REPORT UPDATE

Application No: AB/109/20/HH

Recommendation Report for Planning Permission for Works or Extension to a Dwelling

PROPOSAL: Rear single storey extension for new kitchen and living area, internal alterations, new and adjusted windows and doors, part replacement roof structure with 2 x conservation roof lights to the main building, re-covering of main roof and partial re-build of the detached garage with replacement pitched roof. This application affects the character & appearance of the Arundel Conservation Area & may affect the setting of listed buildings.

PROPOSED GROUND FLOOR PLAN

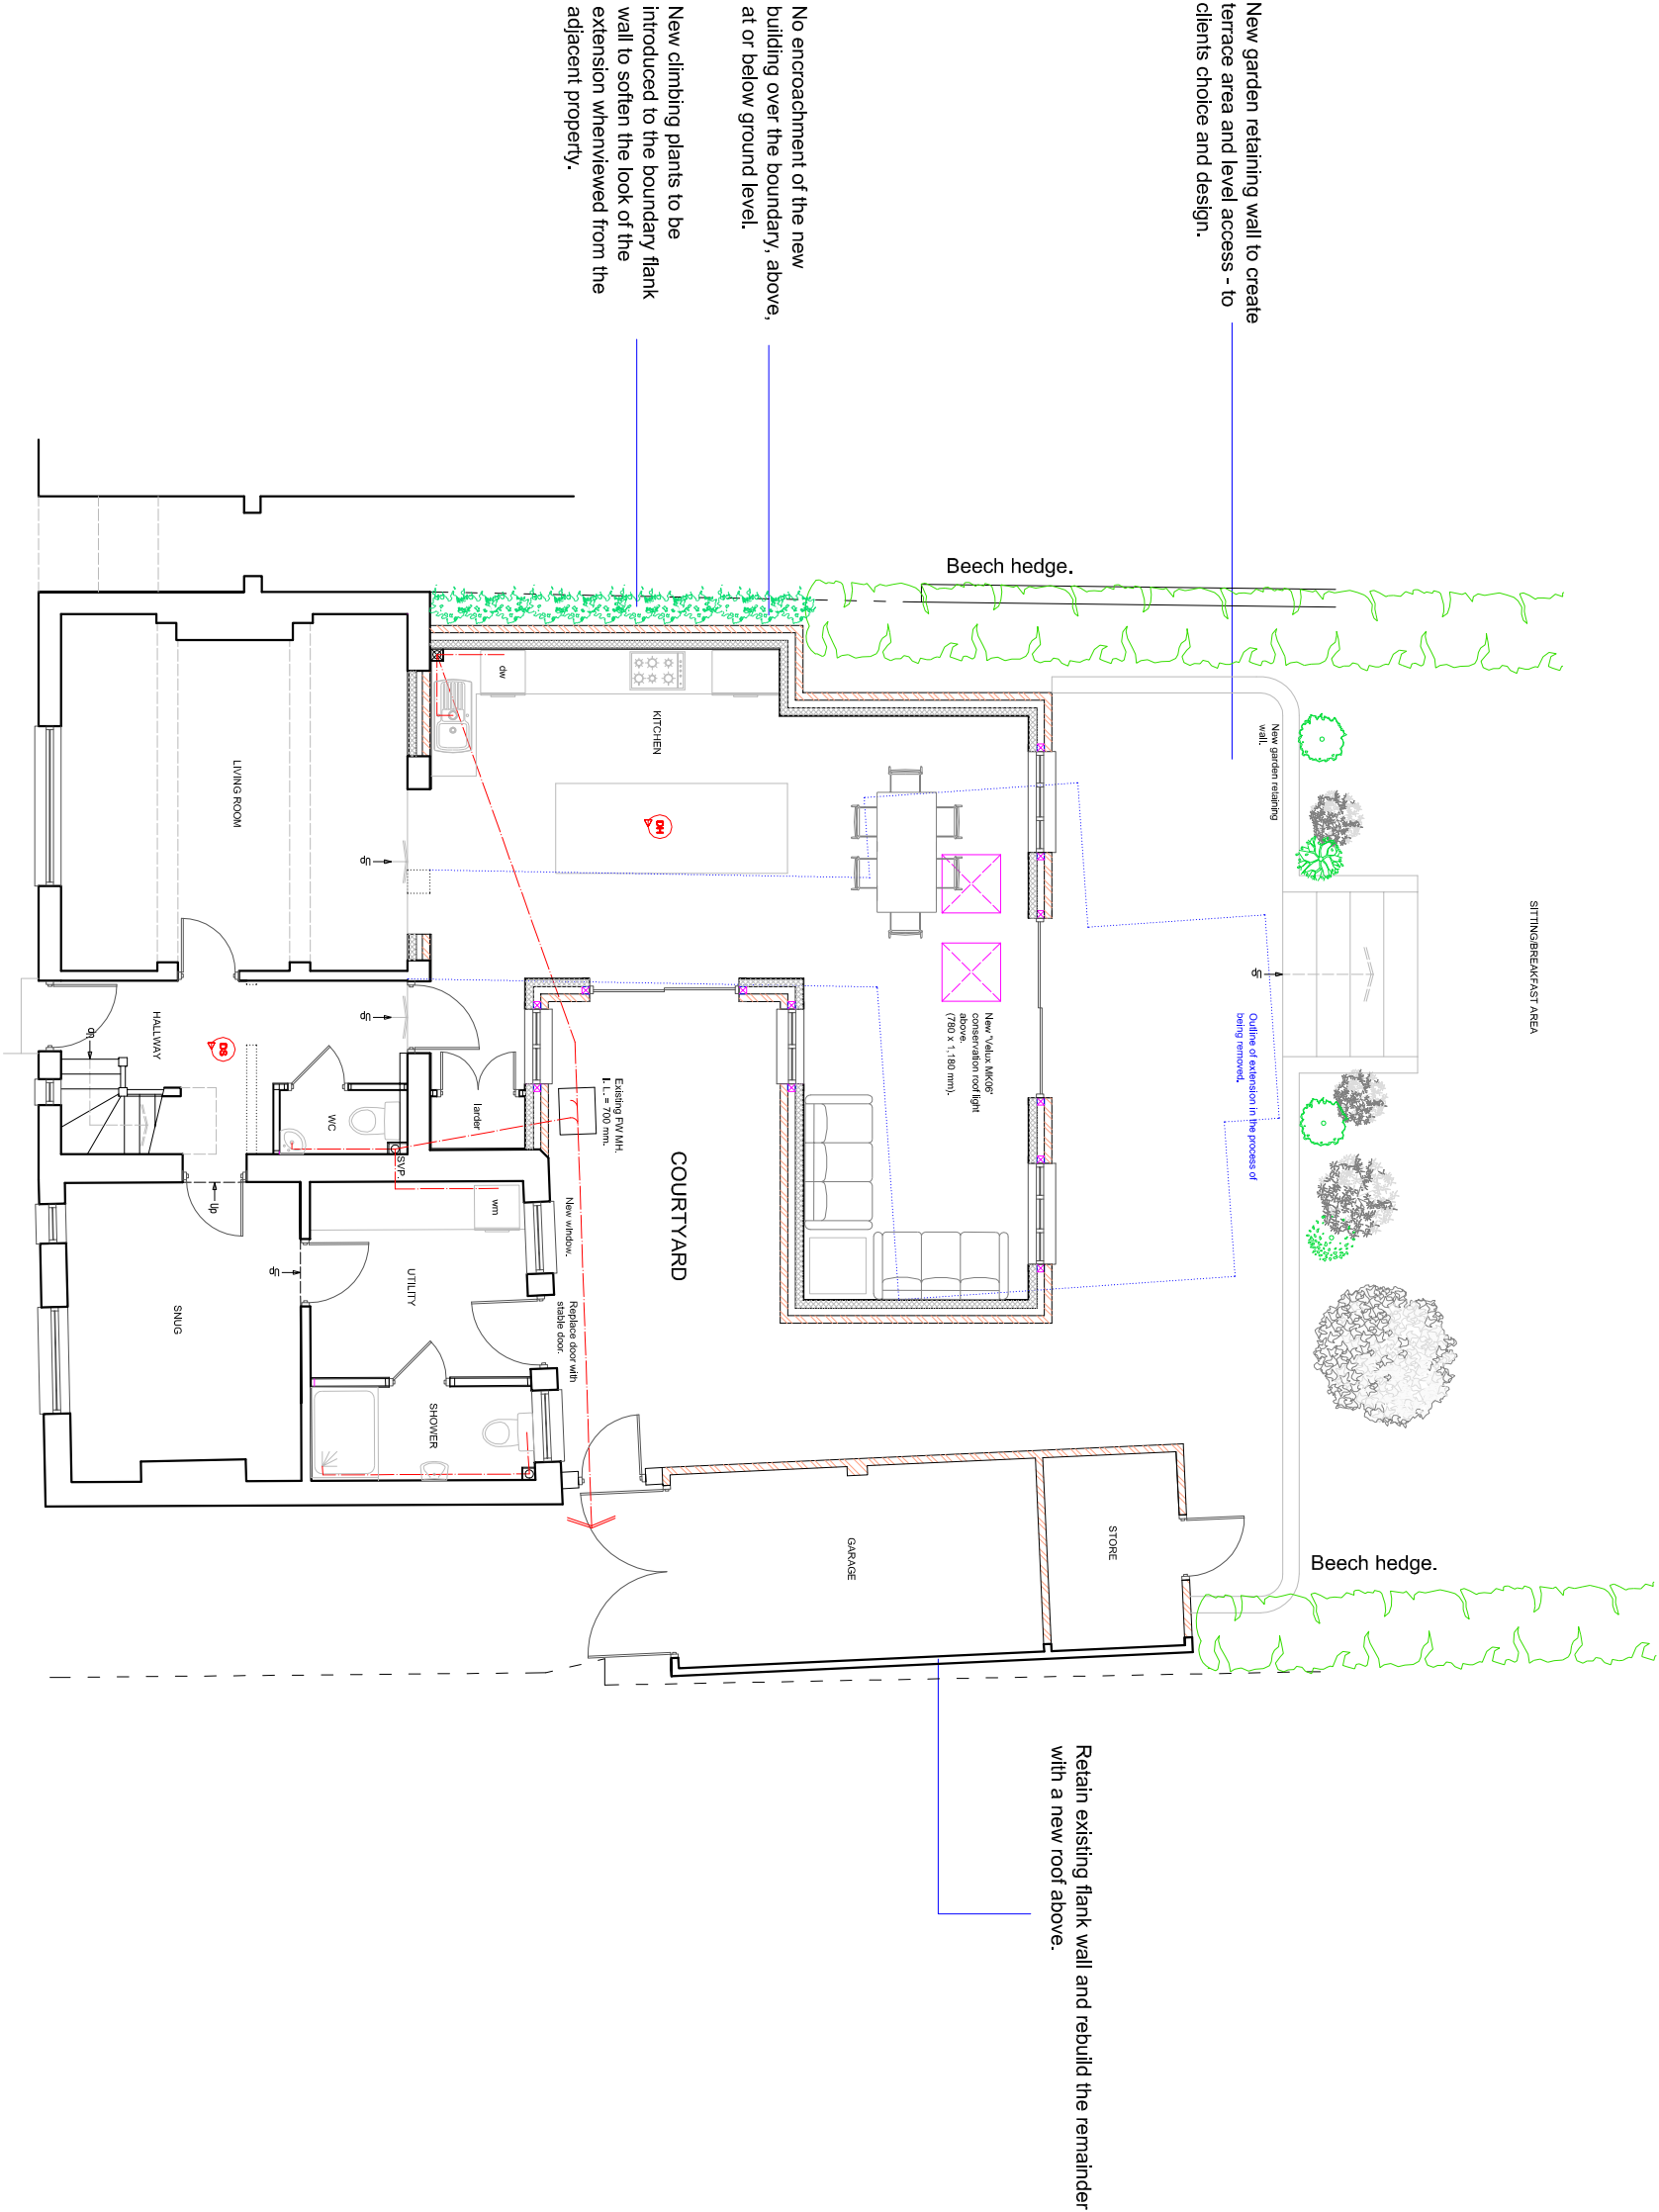
During the process of the application, the plans have been amended to alter the built form of the proposed rear extension. The rear extension has been moved further away from the boundary with the neighbour to the north. This is considered to have a positive impact upon the proposed development, in that the element that has been stepped in was the higher element of the proposal. It also allows for the hedging on this boundary to be retained.

This differs from the extension proposed under this application, in that the proposal is 10m long, 8m wide and approximately 3.8m high (when taken at its most extreme points).

The extension has been designed so as not to sit directly on the boundary line and has allowed for enough space for planting suitable to cover the new brick wall which will further reduce the impact on the setting of adjacent listed buildings. The neighbouring listed buildings are predominantly appreciated from their frontages, forming part of an attractive terrace with other terraces in the road. This view will be unaffected by the proposal.

- 4 No development above damp proof course (DPC) level shall take place unless and until details have been submitted to and approved by the Local Planning Authority of means of enclosure and potential shrub planting along the boundary between the host dwelling and the neighbouring dwelling to the North. The extensions shall not be occupied until such boundary treatment has been installed/planted in line with the approved details and retained as such in perpetuity.

- 5 Prior to commencement of the development, details of the retention of the beech hedgerow on the northern boundary wall should be submitted to, and agreed by the Local Planning Authority in writing. The measures should remain in place for the duration of the construction of the proposal and adhered to thereafter.

PROPOSED ELEVATIONS

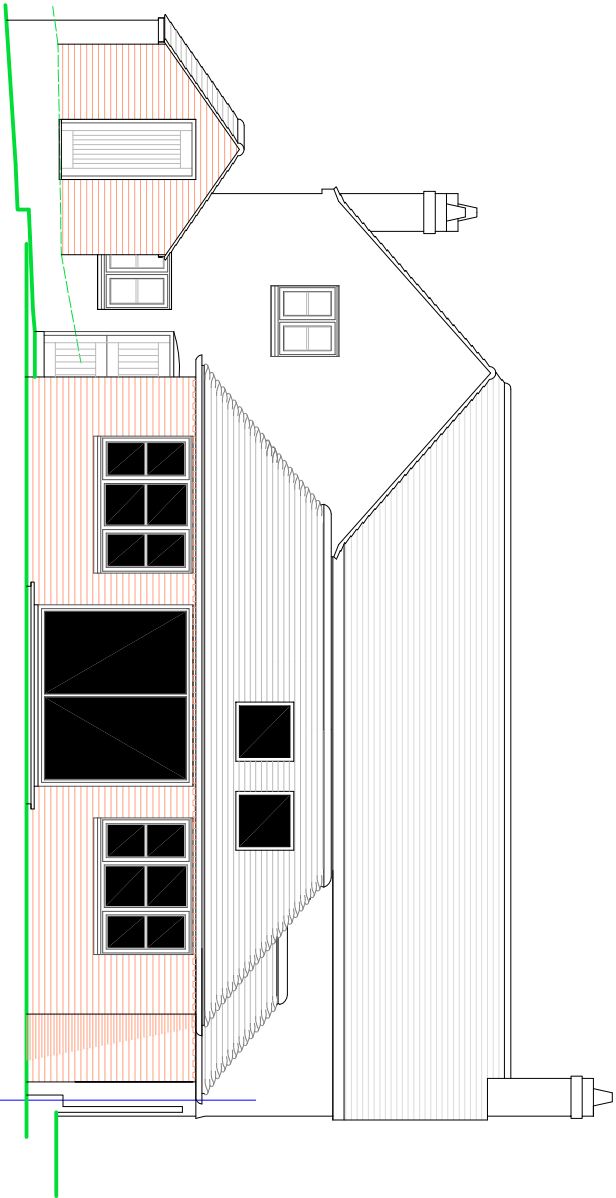
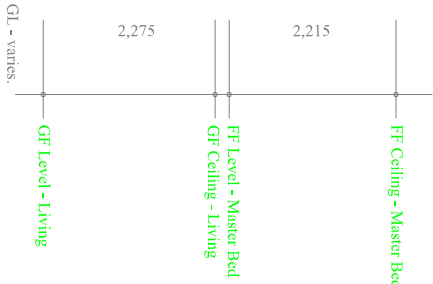
- The proposed development is considered to cause less than substantial harm to the character of the Conservation Area of the setting of the neighbouring listed building.
- The removal of the clay hanging tiles would be unacceptable, details of all materials should be required via condition.
- The use of UPVC windows is unfortunate.
- The works to the roof will receive support.
- The proposal result in the removal of the hedge, details of an alternate means of enclosure along the Northern boundary will be requested via condition.

The proposed single storey rear extension projects from the Eastern elevation of the host dwelling by approximately 9m. Due to this siting at the rear of the site this extension will not be visible from the street scene of King Street. As a result of the topography of the application site, sloping down from north to south excavation has had to be carried out in order to level the land upon which to build the extension. The proposed rear extension itself is considered to appear subservient to the host dwelling, and well integrated with its built form. This is due to the use of materials to match the host dwelling. Furthermore, the eaves and ridge heights of the extension are subordinate in appearance to the host dwelling in terms of their location and height.

The proposed extension is substantial and will occupy a large floor area, but it has a low form and in part replaces an earlier extension. This part of the proposal would not be readily visible in the street scene, being largely screened from view from the site frontage by the existing 2 storey property. The removal of the tile hanging from the front and rear elevations will be controlled by condition. The proposal seeks to replace the modern Marley machine made concrete hanging tiles. These cover the front and rear sections of the house. However historically, tile hanging on this particular property forms part of the established appearance and therefore character of the building. Its loss would detract from the building, especially the front and street elevation and this part of the proposal will be controlled by condition.

The proposed development has an eaves height of 2.4m from within the development site, however, as the application site to the North is higher, this eaves height is 1.9m when viewed from the ground level of the neighbouring site. This eaves line runs along for approximately 5m along the Northern boundary of the site, before stepping in for the remaining 3.2m.

The proposed extension then slopes up to a maximum height of 3.5m when 3m from this Northern boundary. There will be views of the roof of the proposed extension from the rear garden of the neighbouring dwelling to the north. However, the impact will be acceptable for the following reasons.

- 3 Notwithstanding the material details provided on the approved elevation plans no development above damp proof course (DPC) level shall take place unless and until a schedule of materials and finishes to be used for external walls, roofs, windows and all fenestration of the proposed development have been submitted to and approved by the Local Planning Authority and the materials so approved shall be used in the construction of the development.

PROPOSED ELEVATIONS

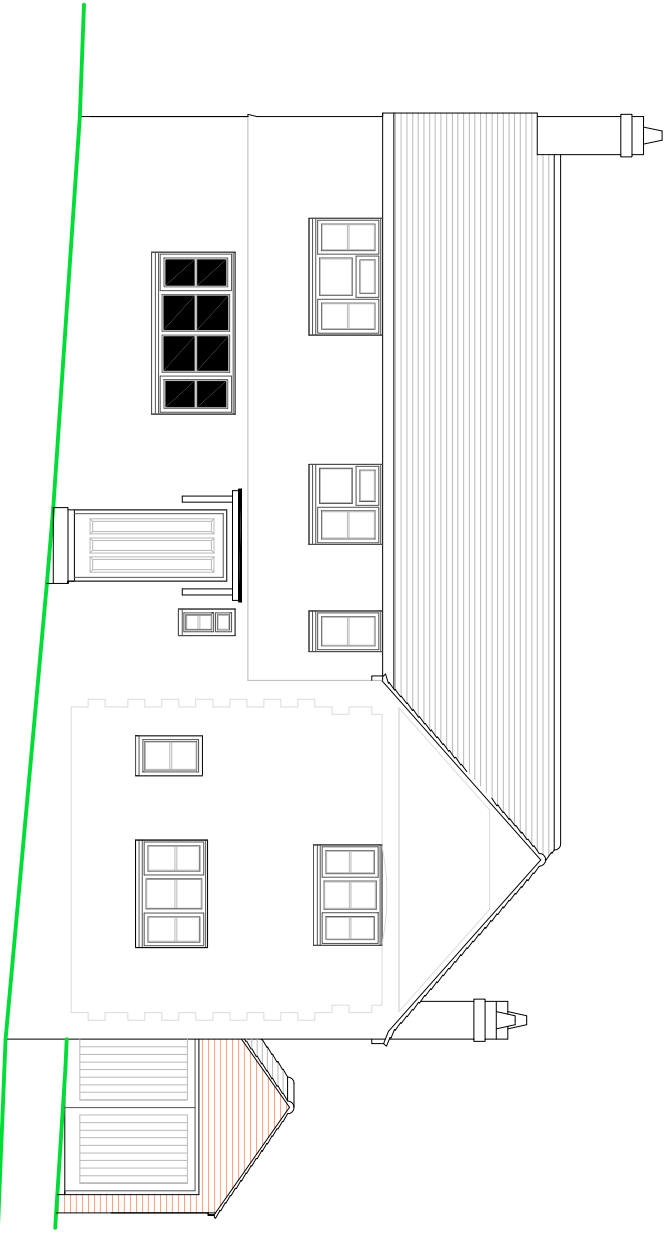
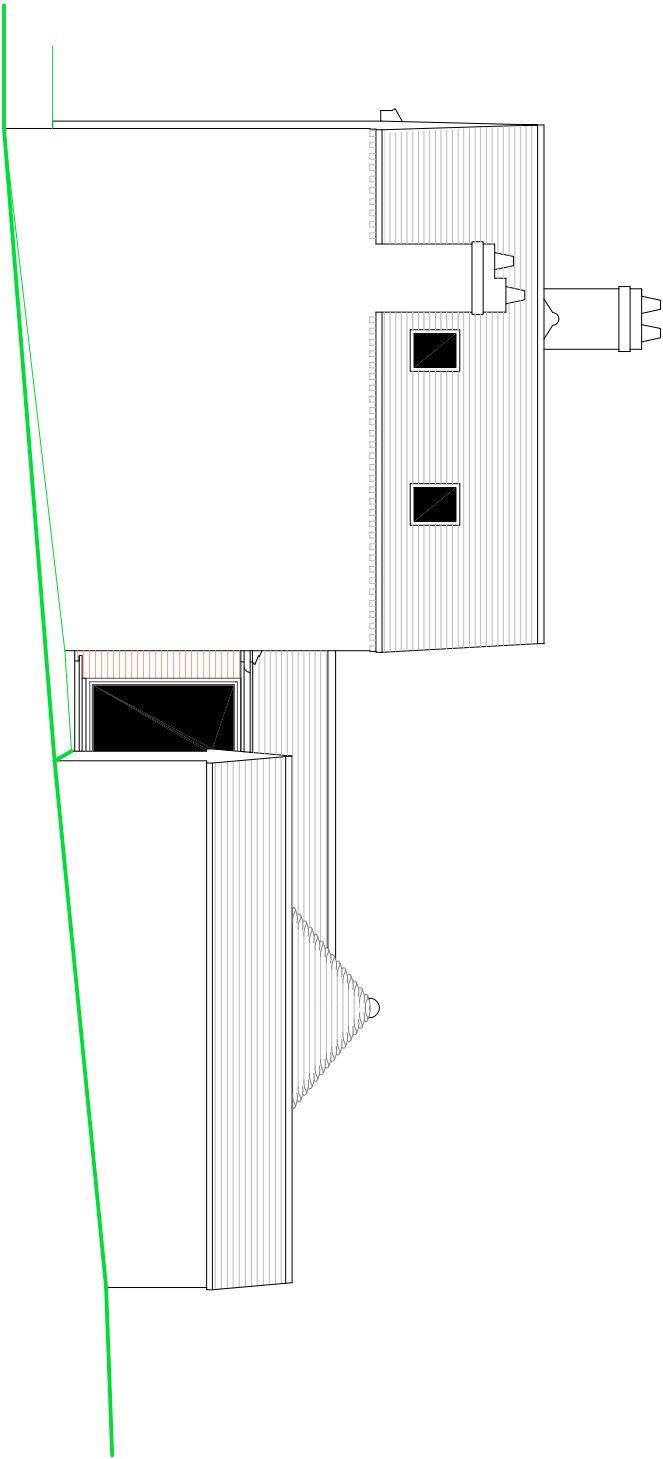
The works to the roof which will see the replacement of the existing tiles with something more appropriate for a conservation area is a positive feature of the application, and is supported. Conservation grade roof lights have been proposed for the extension at the rear of the property and for the southern aspect of the roof on the two storey section of the house. Although roof lights are primarily positioned at the back of properties within the conservation area of Arundel there are few examples where they have been positioned to be visible from the road.
